**KIRKLEES METROPOLITAN COUNCIL
INVESTMENT & REGENERATION SERVICE**

DELEGATED DECISION TO DETERMINE PLANNING APPLICATIONS

Reference No:	2023/62/91332/W
Site Address:	7, Lower Greave Road, Meltham, Holmfirth, HD9 4DY
Description:	Erection of single storey rear extension (within a Conservation Area)
Recommending Officer:	Laura Yeadon

DECISION – CONDITIONAL FULL PERMISSION

Dwg SL2

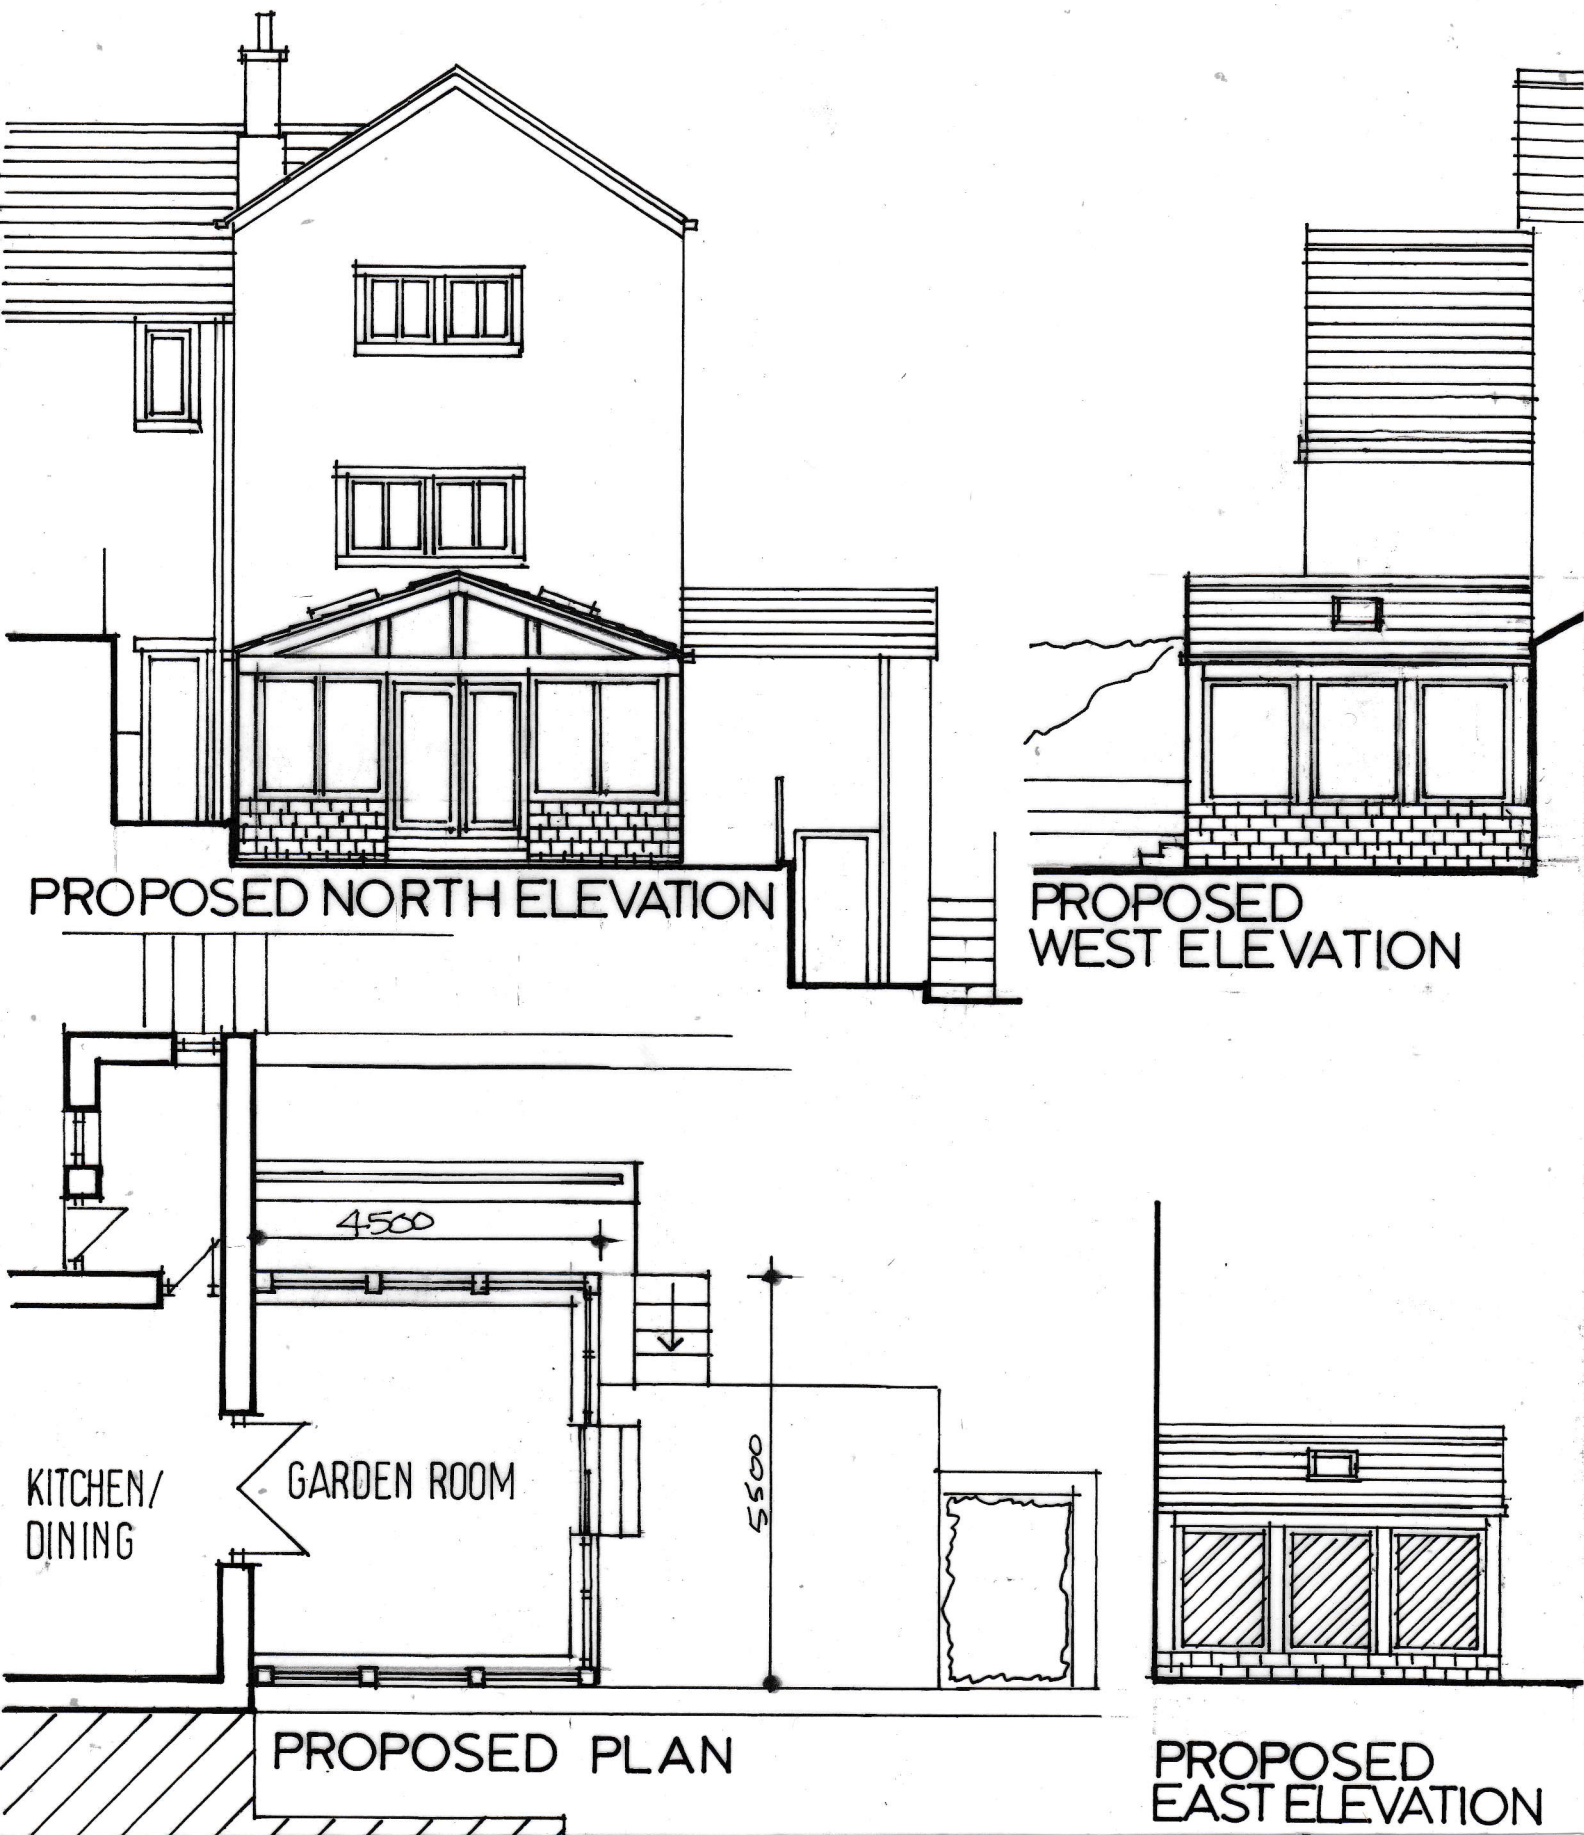
The proposed extension would be located to the rear of the property projecting from the rear elevation by 4.5 metres being a total width of 5.5 metres. The proposed extension would be located on the shared boundary however would be set in from the retaining wall with the adjacent property.

Whilst the projection would exceed the limitations set out within the SPD, it is not considered that the proposed projection would be harmful to visual amenity. The extension would be in an isolated position to the rear of the property, single storey in height, set below the habitable accommodation within the attached property and therefore subservient. Due to the contrasting style of development and by adding an oak framed structure, the extension would be clearly read as an extension to the dwelling.

The proposed construction materials have been updated by the Agent. The plans indicate that the extension would sit on a stone dwarf wall and the updated information confirms that the extension would be a timber framed structure in Green Oak. The application form also confirms that the roof would be stone slate to match the existing. These proposed materials are considered to be acceptable and would comply with Key Design Principles 1, 2 and 9 of the SPD, Policy LP24 and LP35 of the Kirklees Local Plan and advice within the NPPF.

In terms of residential amenity and compliance with the SPD whilst noting that the extension would be set in from the retaining wall to the attached neighbouring retaining wall, as shown on the submitted plan, the extension would be on the boundary line and retains access to the lower ground floor door to No. 9. Whilst this element of the scheme would not be set in by at least 1 metre as prescribed within the SPD, due to the difference in levels, the extension would be set adjacent to a retaining wall whereby the roof of the extension would be the only part of the extension which could impact on the habitable accommodation and garden area for the attached neighbouring property. As the roof would be approximately 1 metre in height above the retaining wall, it is not considered that there would be significant harm from overlooking, overshadowing or by being overbearing to this attached neighbouring property.

Key design principle 5 of the SPD recommends that the 45-degree rule should be treated as a starting point in assessing impact for all extensions, i.e. a line drawn from the midpoint in the nearest adjacent habitable room window at an angle of 45 degrees should preferably not intersect the extension. In this instance, the submitted plans indicate that the extension would have a comparable projection to the retaining wall and therefore, as the proposed extension would be at lower ground floor level to the adjacent property, it is not considered that a 45 degree line would be obscured.
